From: Michael Eastham
Sent: 02 November 2017 10:35
To: 'Owen Allpress'; 
Cc: Zoe Knott; Chris Fry; Adam Ross; Natasha Bullen
Subject: RE: Email 3: South of Water Lane, Angmering

The main objection, although not originally clear, is that the AIA provided shows the masterplan as such a scale that prevented Bernie from being able to comfortably understand the impact. It may also appear that I do not have the latest masterplan as Bernie refers to a large block at plot 175 which is not shown on my most recent AIA (see screen shot). Bernie also confirmed that comments relating to T29 are in relation to the large scale of the AIA and isn't an issue now given distance, (See screen shot).

Tree Protection Plan

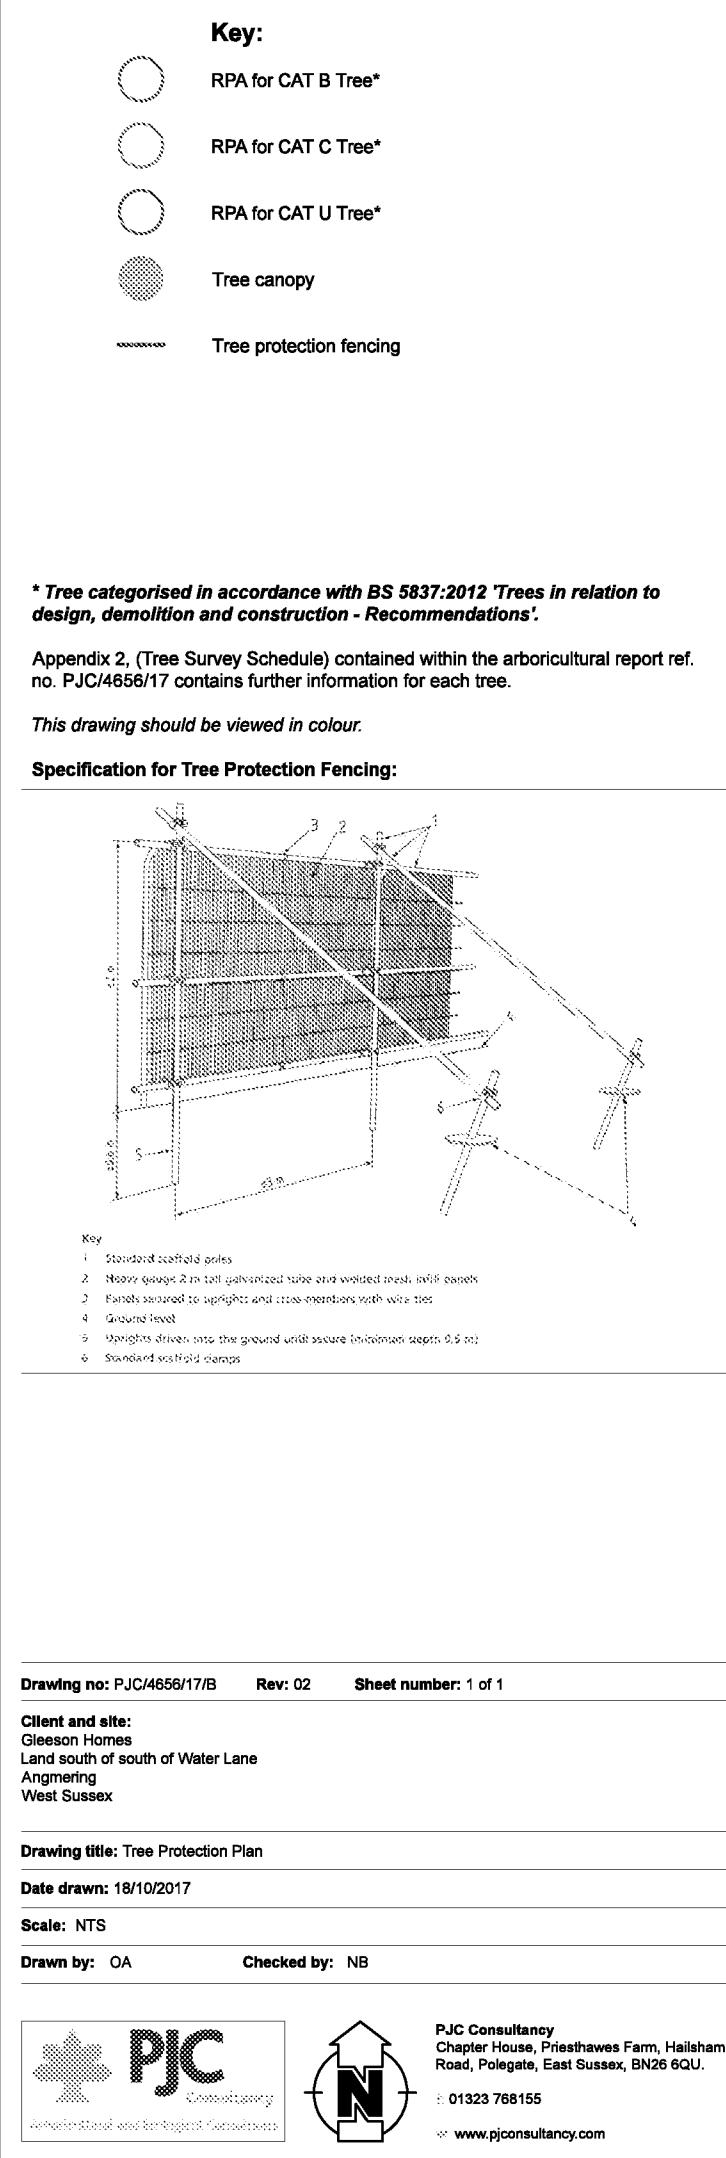
- Layout amended to reduce pressure on Tree G31 by houses at the northern boundary.
- Repositioning of a 'large block' to limit impact on Tree T37 which is not evident on your current AIA. This point may require clarification by the applicant.
- Updated AIA containing several (tree retention plans only) at a scale that can assist the reader in observing impact and removal of Tree Protection Plan which should be approached as part of a detailed AMS at full application come the time.

- Layout amended to reduce pressure on G31 by houses at the northern boundary.
- Repositioning of a 'large block' to limit impact on T37 which is not evident on my current AIA. This point may require clarification by Nexus / Pro Vision.
- Updated AIA containing several (tree retention plans only) at a scale that can assist the reader in observing impact and removal of Tree protection plan which should be approached as part of a detailed AMS at full application come the time.
